Re: 159 Charville Lane, Hayes - App. No. 4734/APP/2017/4236 - Drainage Comments

4 June 2018 at 22:32

Proposed
Floor and Roof Plans

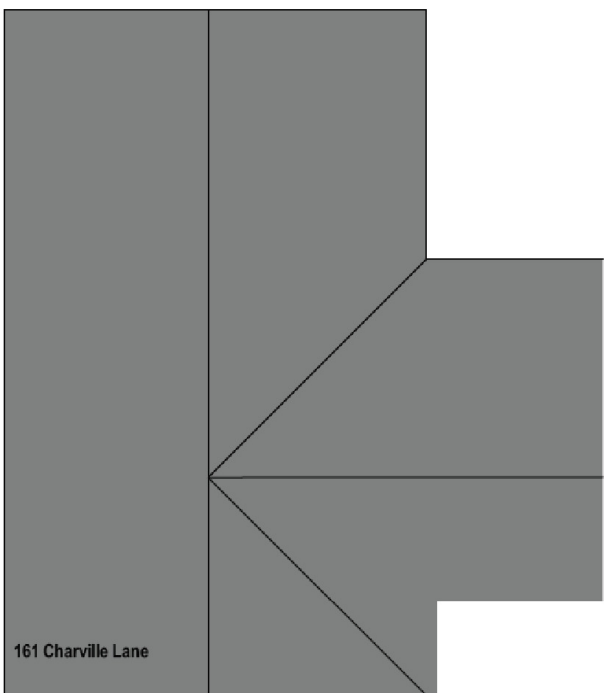
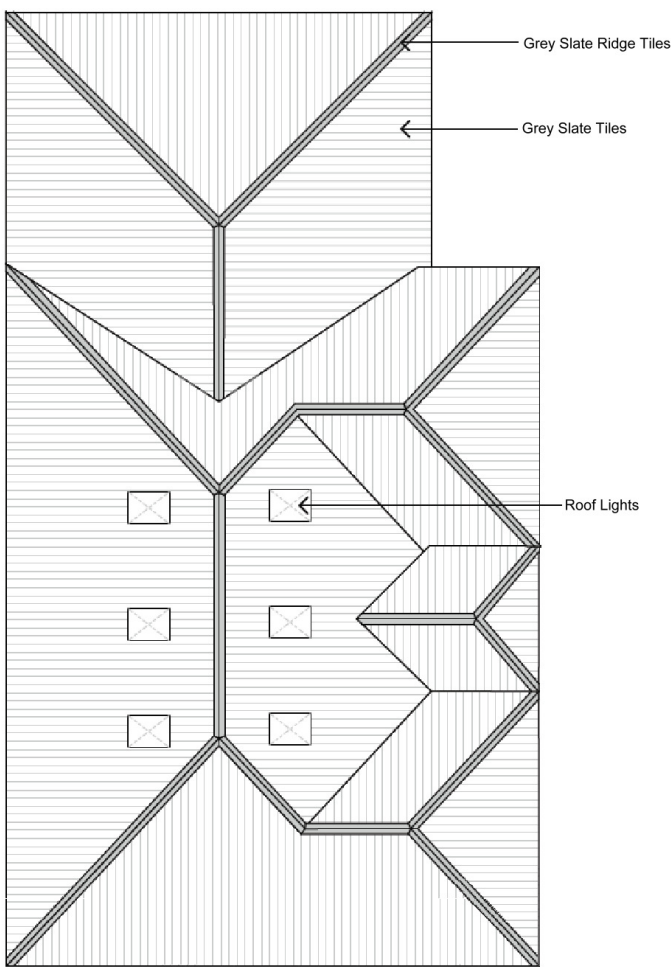
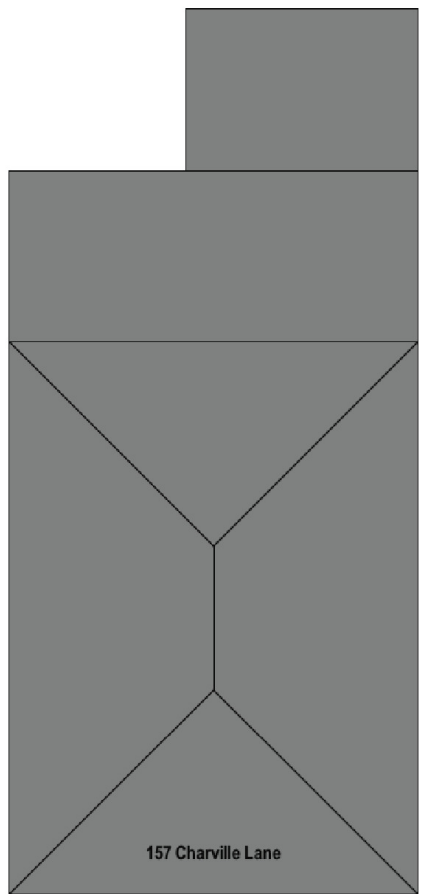
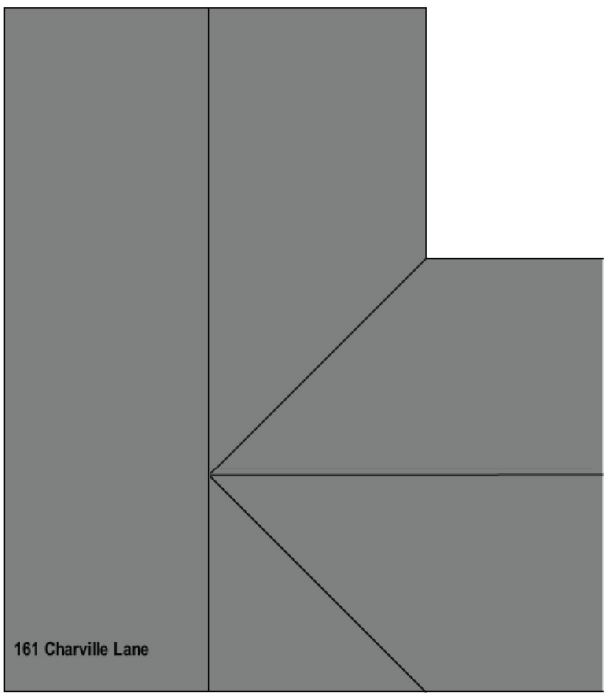
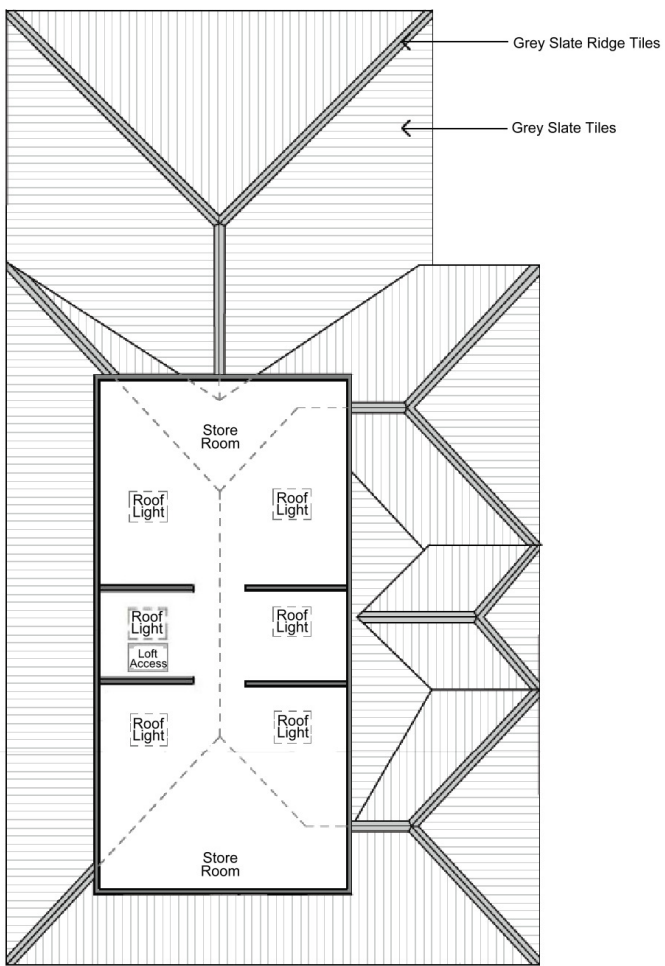
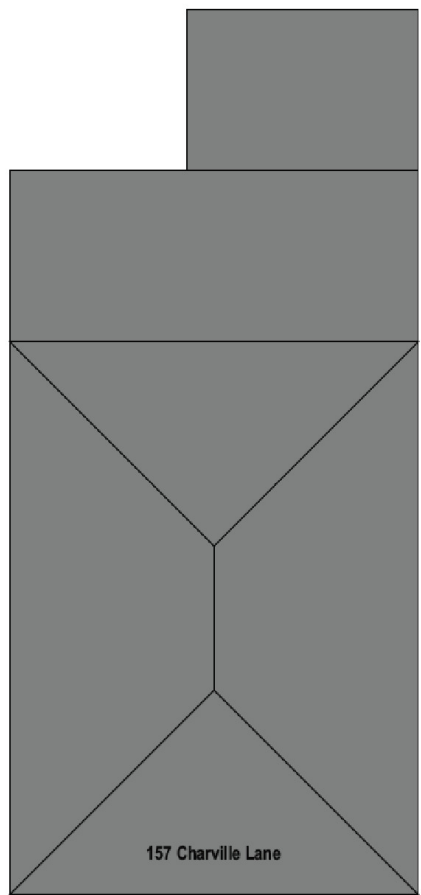
In terms of the maximum size of dwelling, as previously mentioned, taking the 50% guidance rule and with an original floor area of 78sqm, this would give an overall maximum allowable internal total floor area of $78 + 39\text{sqm} = 117\text{sqm}$, which would be measured by including all the habitable floor space on both floors. The existing building on site has a total floor area of 184sqm if the front bays and porch are omitted or 136% of the original property.

What would assist is if the first floor could be made non-habitable, ie just loft space. It is already shown as only providing storage space so if access was restricted, by replacing the stairs with a loft ladder access, then the first floor would not count towards the overall internal floor area, reducing the increase in floor area to 83%. Any further reductions would be welcomed and make the arguments at committee easier but with the omission of the first floor (and front bays and porch), I suspect that I would be in a position to recommend the application favourably, particularly as I would be able to argue the particular merits of this case and that a former detached garage had been removed.
